**From:** [Marlborough, Neil](#)  
**To:** [Wylfa Newydd](#)  
**Cc:** [Harding, Helen](#); [swyddfa@cyngortrefamlwch.co.uk](mailto:swyddfa@cyngortrefamlwch.co.uk)  
**Subject:** Wylfa Newydd Examination Deadline 2: NACP responses  
**Date:** 04 December 2018 20:15:38  
**Attachments:** [image001.png](#)  
[NACP Construction working hours.pdf](#)  
[NACP Local Opportunities.pdf](#)  
[NACP Residential Amenity.pdf](#)  
[NACP Suggested site visit locations .pdf](#)  
[NACP Temporary workers accommodation.pdf](#)  
[NACP Tourism and recreation.pdf](#)  
[NACP Traffic and Transport A5025 Tregele.pdf](#)  
[NACP Traffic and Transport crosscountry routes.pdf](#)  
[NACP Traffic and Transport other matters.pdf](#)

# Wylfa Newydd Nuclear Power Station:

## NACP Written Representation: Tourism and recreation

Drawing Title  
WALES COAST PATH

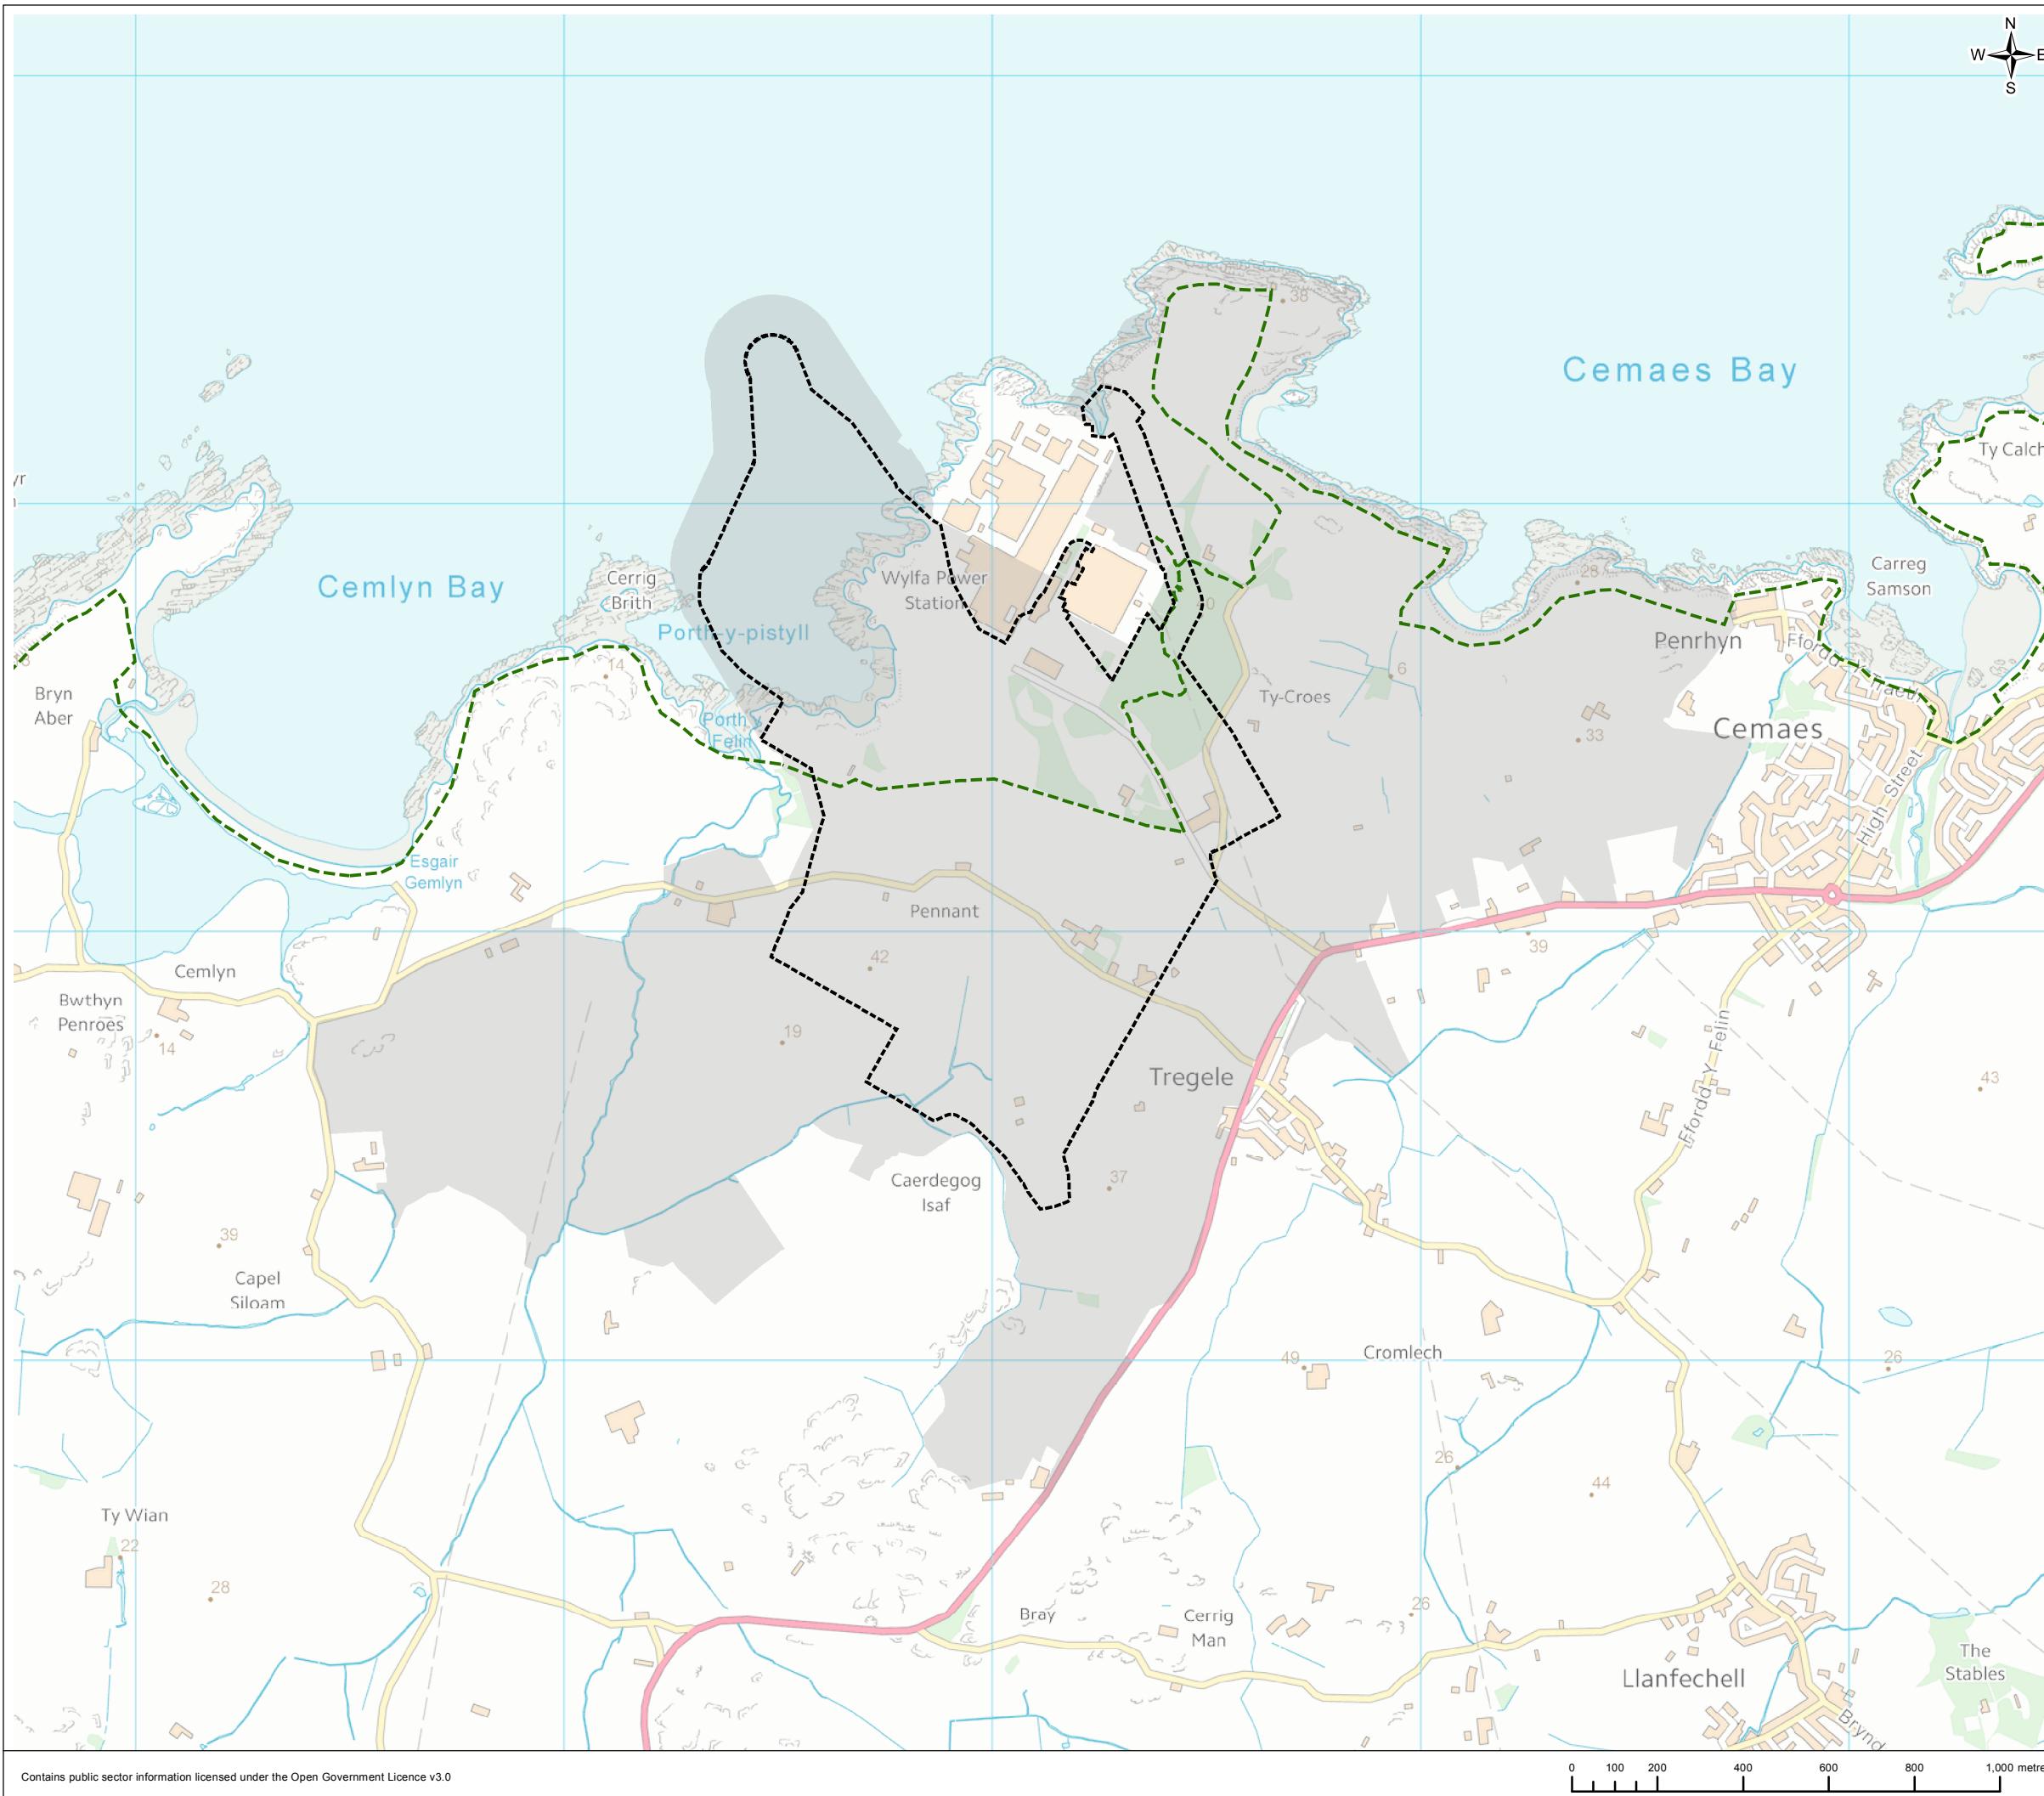
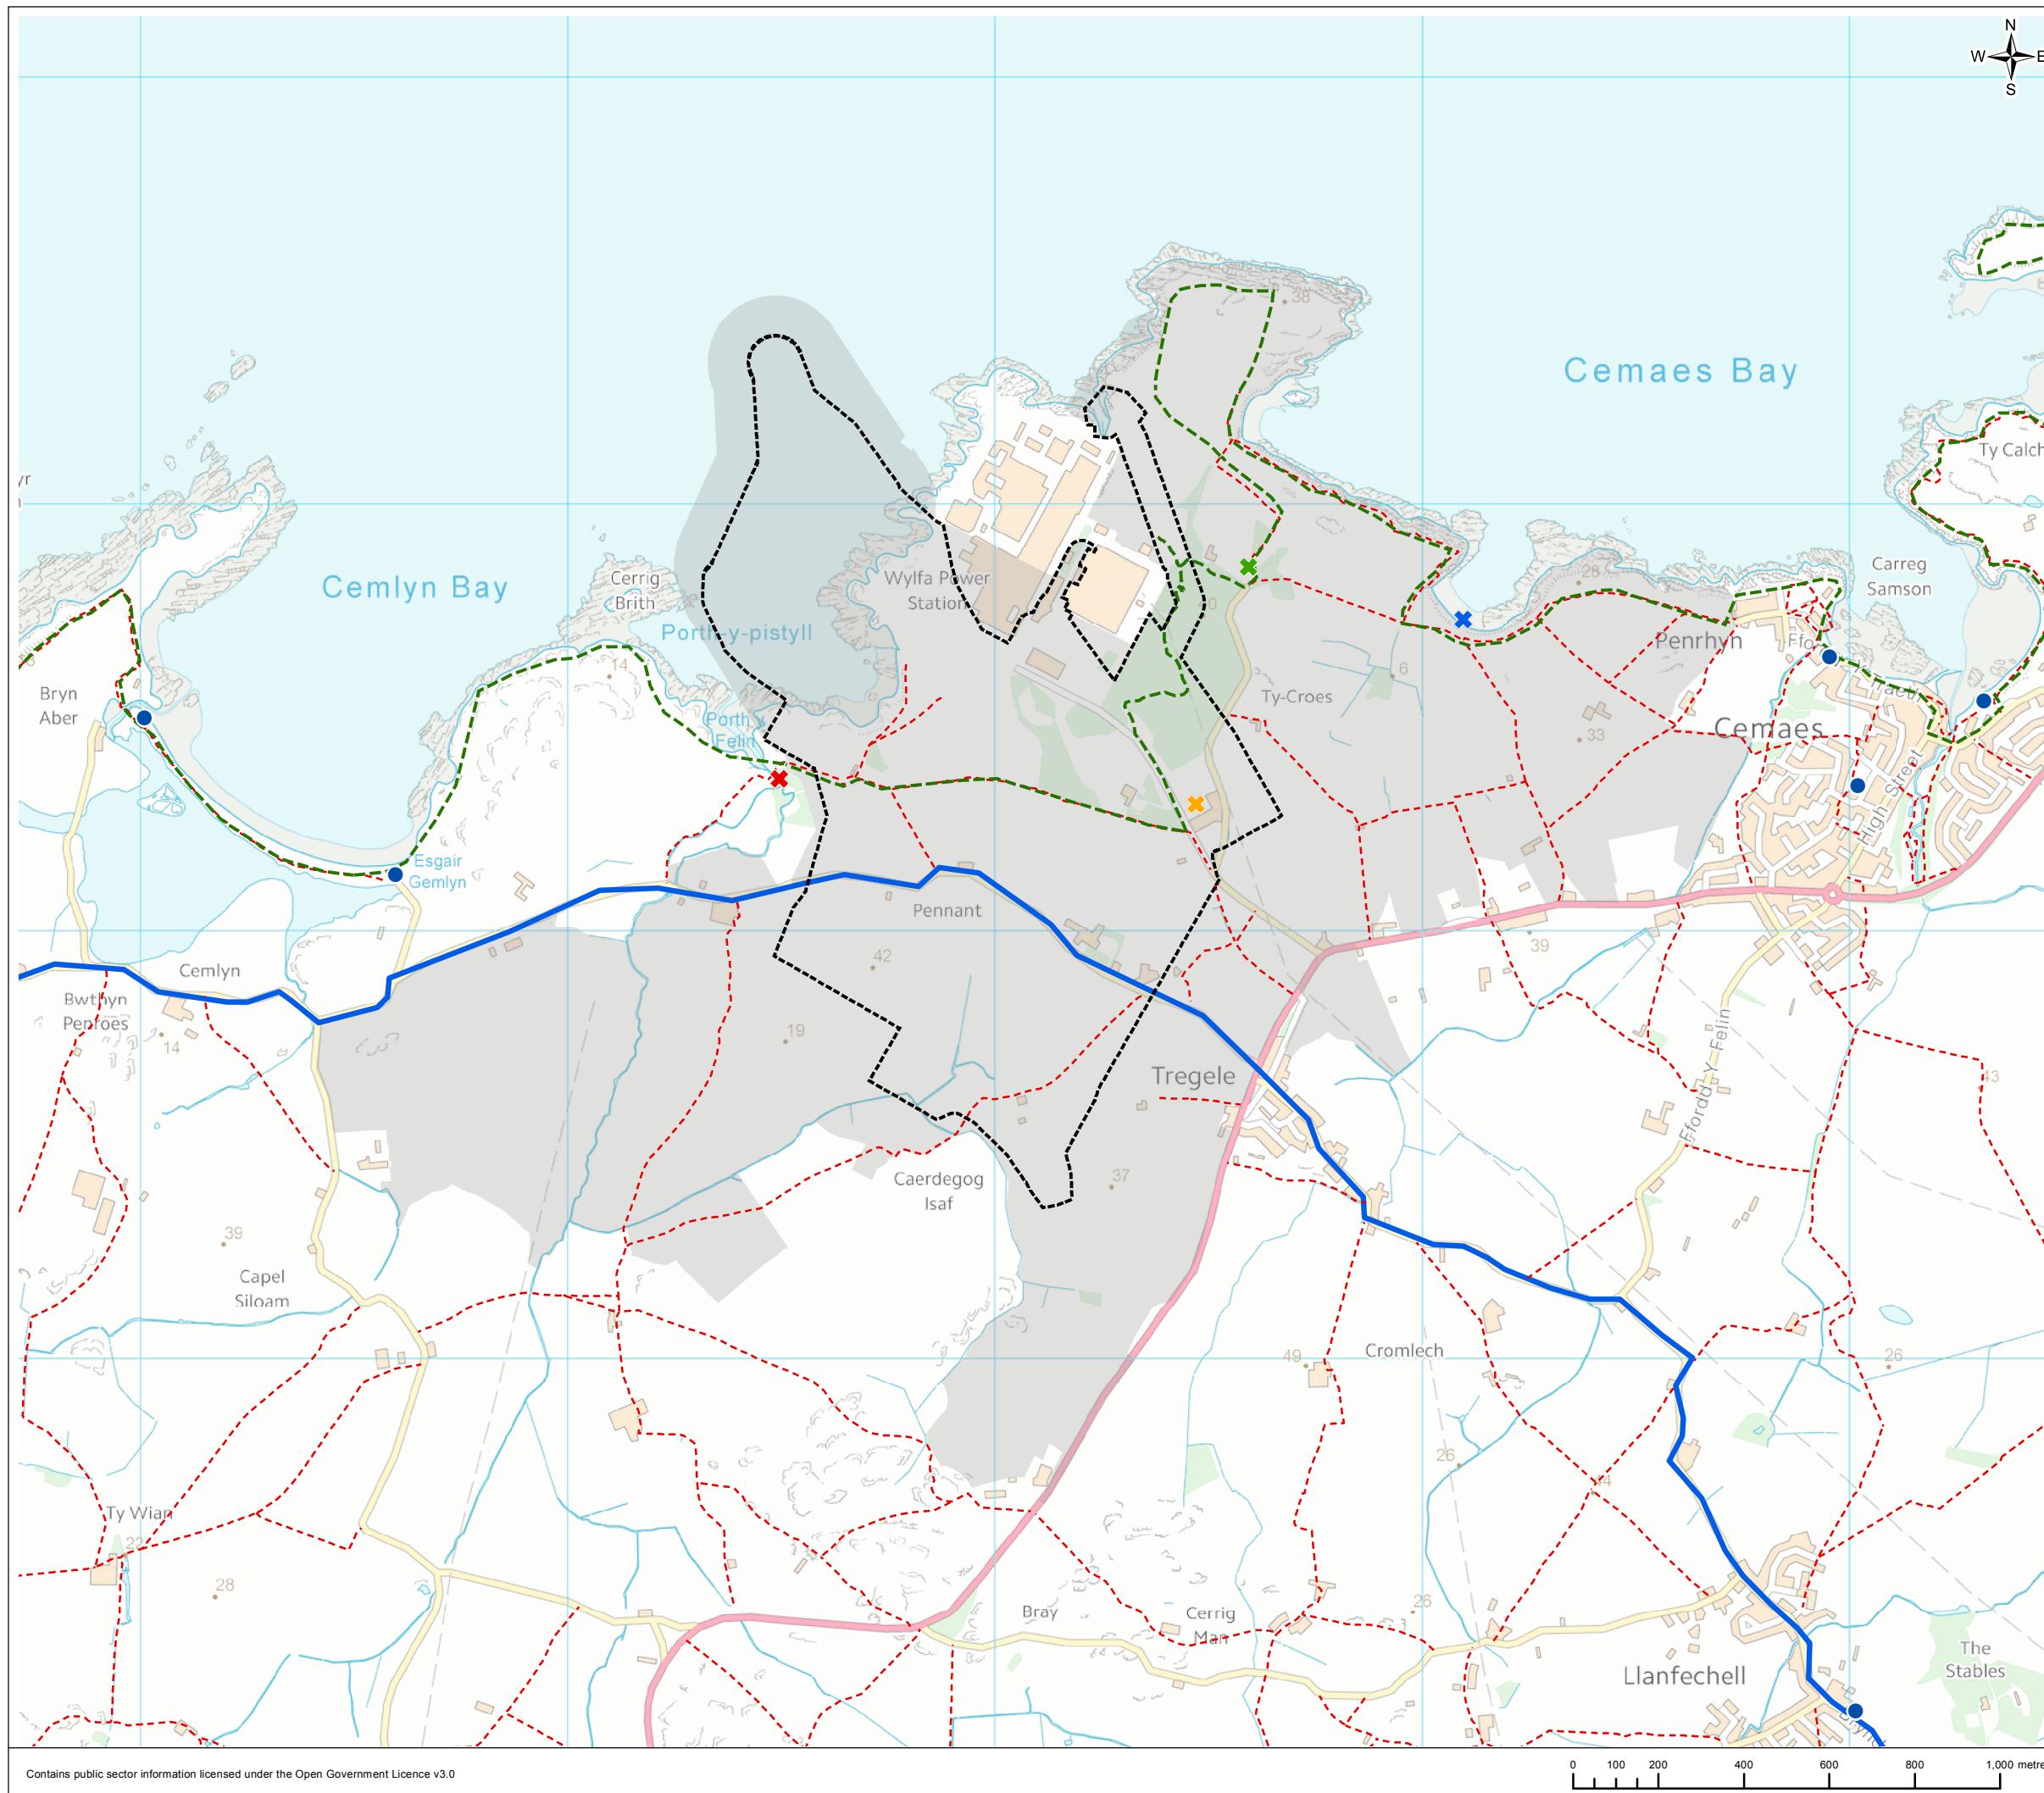
3.2.1 During the construction phase it is acknowledged that there could be significant health and safety issues from the Wales Coastal Path running through the WNDA but the NACP are concerned with the length of the diversion proposed, both in terms of the additional length created for walkers and the amount of time the diversion would be in place for. Walkers travelling between Cemaes and Cemlyn Bay would presently cover a distance of approximately 6.4km, of which 3.7km could be described as being adjacent to the coast. The proposed diversion would be 6.9km long, none of which would be adjacent to the coast. A spur to Wylfa Head would still be available, but any walker wishing to visit this location would need to walk approximately 4.2km, in addition to the 6.9km diversion. This diversion for the construction phase would be in place for 9 years.

3.2.2 Whilst walkers who are completing long-distance sections of the Wales Coastal Path may not consider this to be an overly restrictive diversion, or dissuade them from completing the long distance as a whole, walkers who are completing day visits to the area and shorter walks may be discouraged from visiting. In addition, Horizon themselves acknowledge the high use of the Wylfa Head area by local people for recreational purposes with many using the Fisherman's Car Park rather than walk from Cemeas out to Wylfa Head (APP-123, Doc 6.4.4, para 4.3.53). Businesses in Cemaes who would benefit from passing trade, or local people dropping in after visiting Wylfa Head, may be negatively affected by this, as day visitors avoid this section of the Path.

3.2.3 Further information on this matter is still awaited from Horizon and the NACP would wish to make a final consideration on this matter once this information is received. If an inland route is required however, the NACP believe more should be done to follow the phased approach to construction with the diversion to the Wales Coastal Path being amended during the construction in response to areas of land being moved out of construction use and into their restored state. The two most obvious areas of land would be around Mound A and Tre'r Gof SSSI in the north east of the WMNDA and around Mound E and along the Afon Cafnan in the west.

3.3.1 Once operational, the construction diversion would be replaced by a permanent diversion. This would reconnect the Wylfa Head spur with the linear route of the Wales Coastal Path, but then provide a route that runs inland to Tregele before taking a winding route to the south and west before re-joining the existing Wales Coastal Path at Cestyll. This inland section would run for approximately 5.7km.

3.3.2 The NACP is disappointed that a coastal route for the permanent Wales Coastal Path is not being pursued with the decommissioning of Wylfa A and the cessation of construction activities around Porth-Y-Pistyll providing a seemingly good opportunity for this to occur. The NACP await further information (which has been promised by Horizon) on this subject and would wish to make a final consideration on the matter once this information is received. However, should the proposed inland

route be necessary, it does appear to be longer than is necessary and the NACP do not believe that Horizon have placed sufficient importance on the Wales Costal Path in the restoration proposals and improvements could be made to the proposed route. For example, it appears that a route for the Wales Coastal Path could be closer to the eastern side of the Power Station Site and also across the eastern side Mound D to reduce the length of time and distance walkers would be away from the coast. This shorter route was presented in Horizon's Stage 3 Consultation (Figure 2.8 of the Main Consultation Document) and no explanation appears to have been provided as to why a longer route has been proposed in the submission documents.
